From: Bloomer, David <David.Bloomer@lancashire.gov.uk>
Sent: 01 August 2018 12:50
To: John Macholc
Cc: LHS Customer Service; planning
Subject: app3/2018/0363 Th ePinch Bowl , Hurst Green

The proposal is for the conversion of the existing building , formerly a public house / restaurant into a 5 unit holiday let with associated café and the siting of 15 log cabins within the curtilage of the property. I have commented on a similar applications on two occasions previously in response to submissions made in 2016 and 2017. On both occasions I have recommended that the application be refused predominantly on the grounds that the site has a poor access onto Longridge Road with a visibility splay to the right on exit well below those recommended for a road of this nature with a speed limit of 40mph. Although no site specific speed survey appears to have been undertaken at the site entrance , historic survey data from a site on Longridge Road further to the west would suggest 85th percentile speeds in the low 40mph bracket (43, 44mph). These figures indicate that a visibility splay of 2.4 x 116m is appropriate . The submitted Transport Statement states that 2.4 x 38m is achievable. This is

Former Punch Bowl Inn, Longridge Road, Hurst Green, Clitheroe. For Mr A Donelan	21 03 2017
Proposed re-development to form holiday houses	2765
EXISTING SITE PLAN	SK/32/02

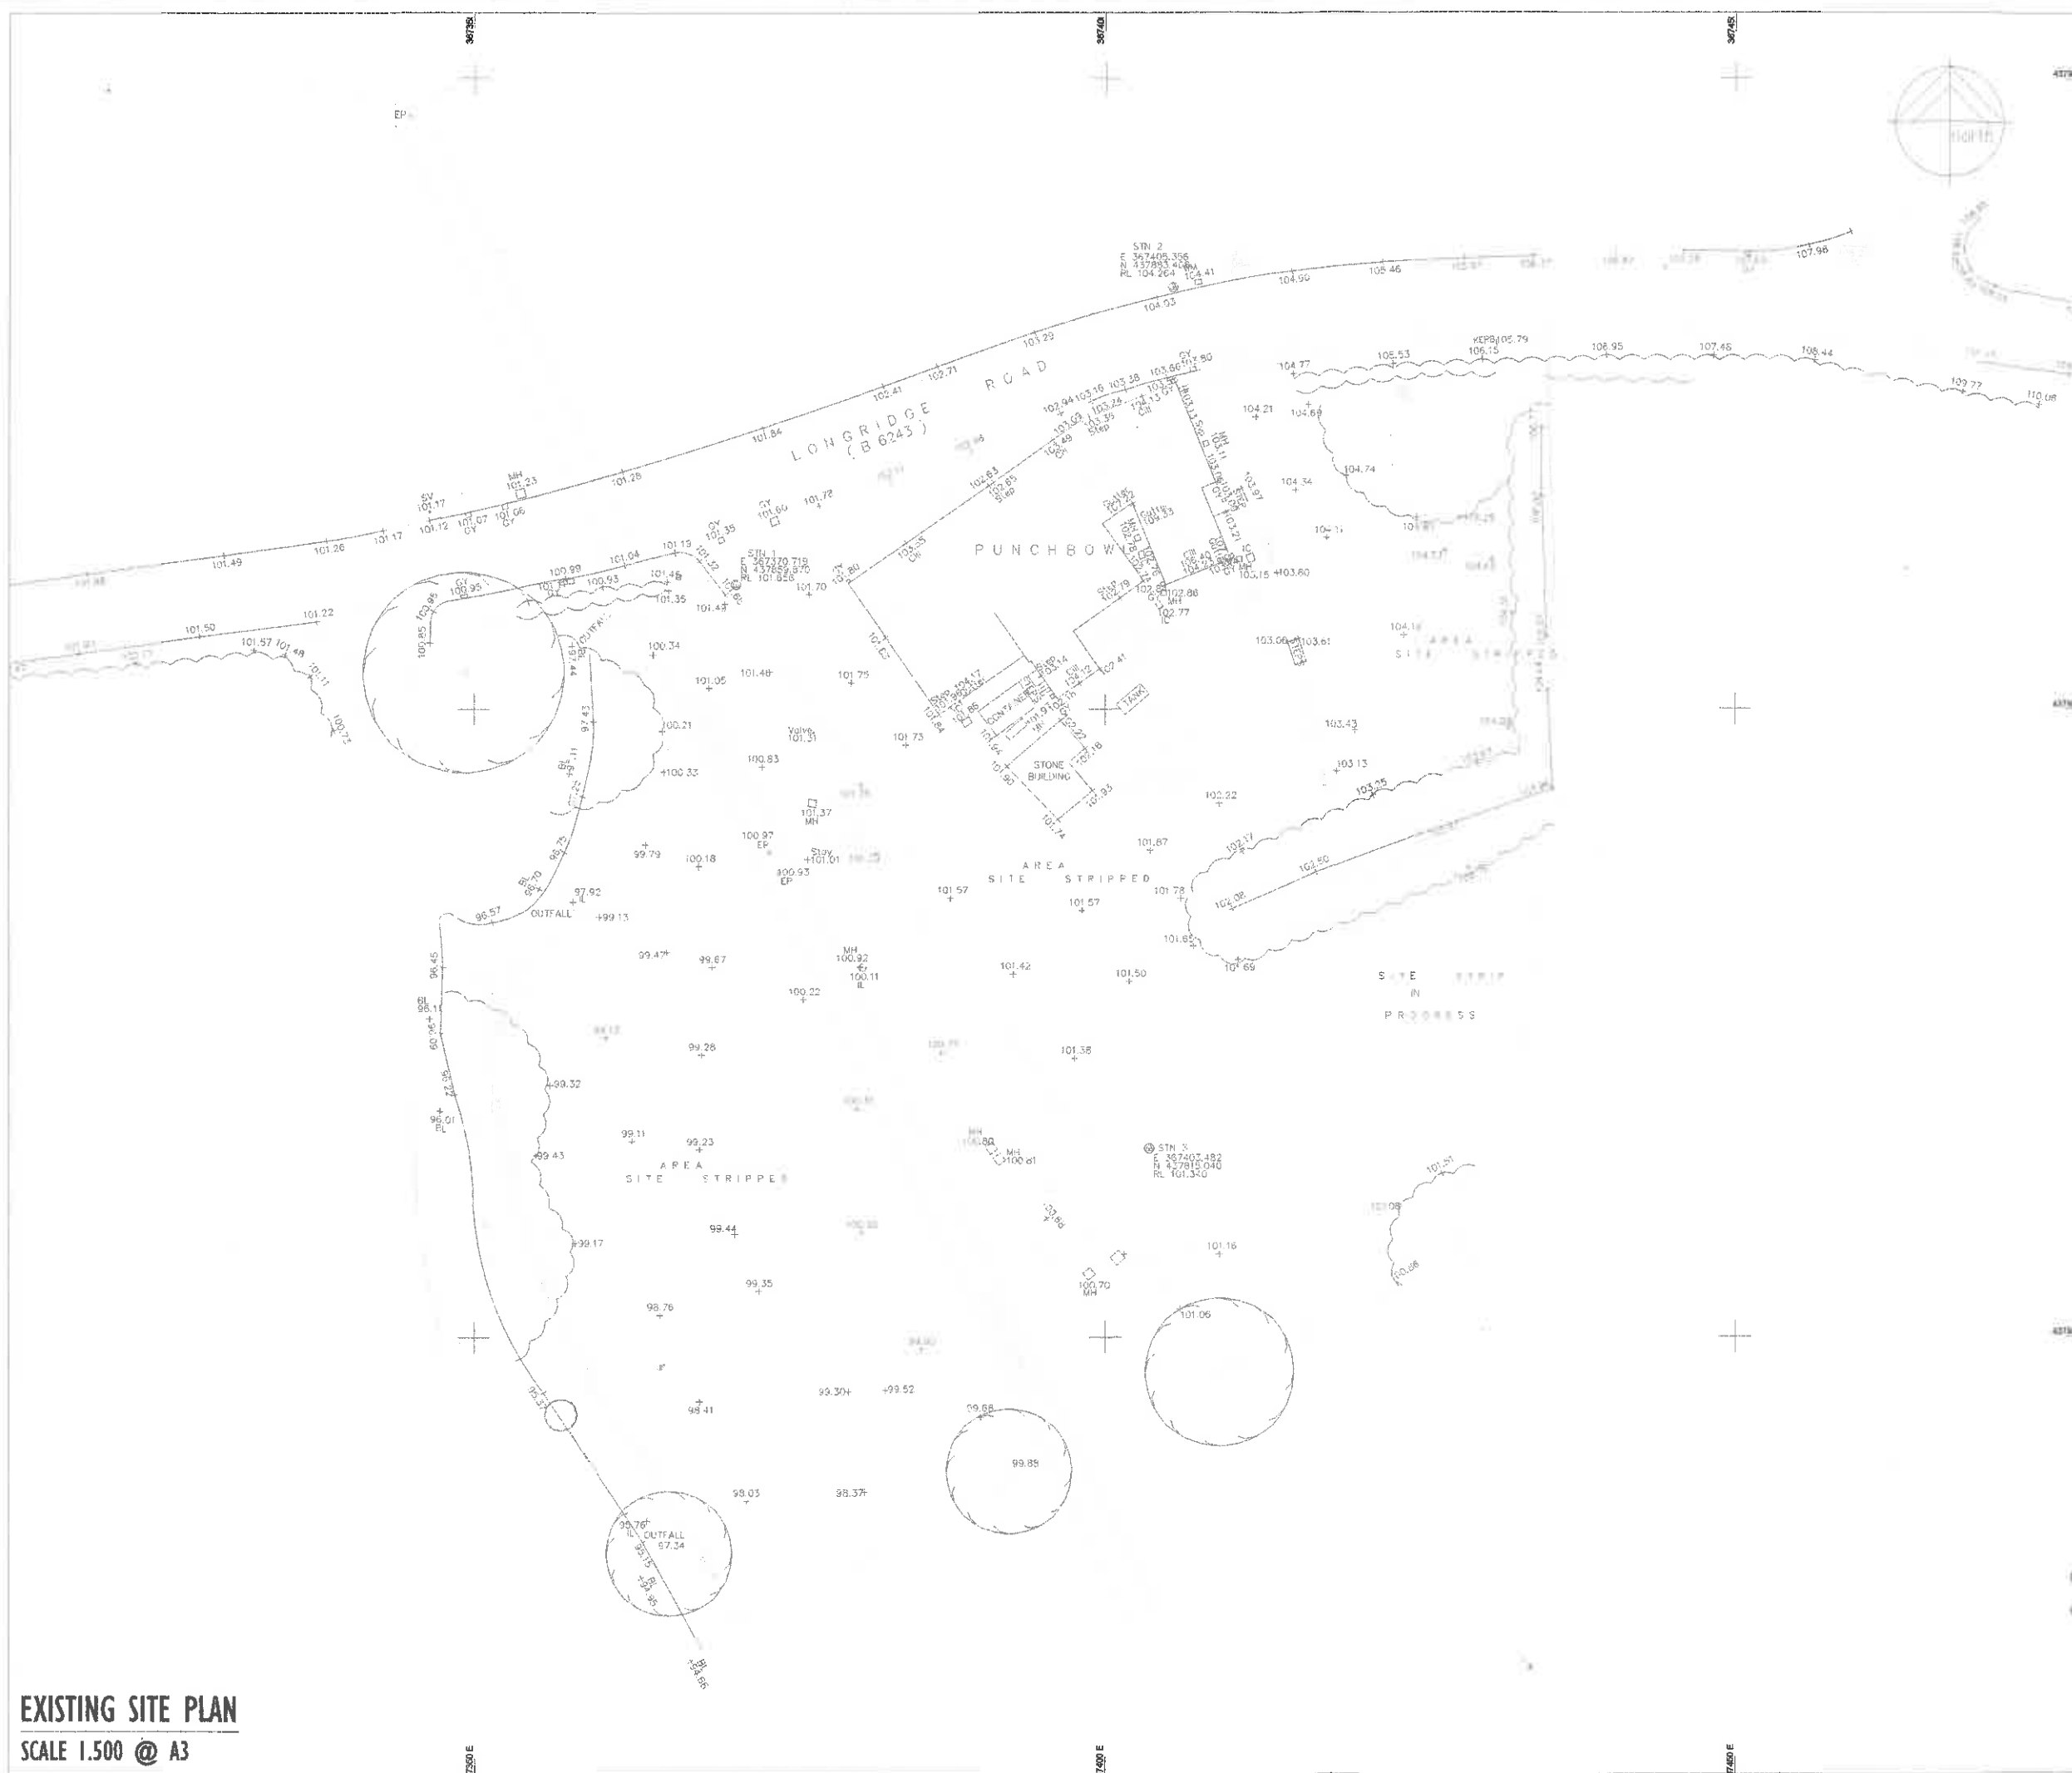
Notwithstanding the clearly inadequate visibility splays afforded at t retained access onto Longridge Road, the argument put forward by the applicant is that the traffic generation associated with the proposed use would be lower than that which could expected from the proposed development as a consequence the potential for a collision at the site access would be reduced. The applicant has failed to take account of the potential traffic generation from the proposed café which will be established on site . This has 68 seats and whilst the available data within TRICS is limited , the nearest equivalent (Little Chef) has a higher anticipated daily flow than the former pub use .The figures derived from TRICS are as follows

On the basis of the above and the previous highway comments, it is clear that the proposed development will lead to an increase in traffic generation from the site which suffers from poor visibility and as such the development represents a potential road safety hazard to road users and should therefore be refused on highway safety grounds.
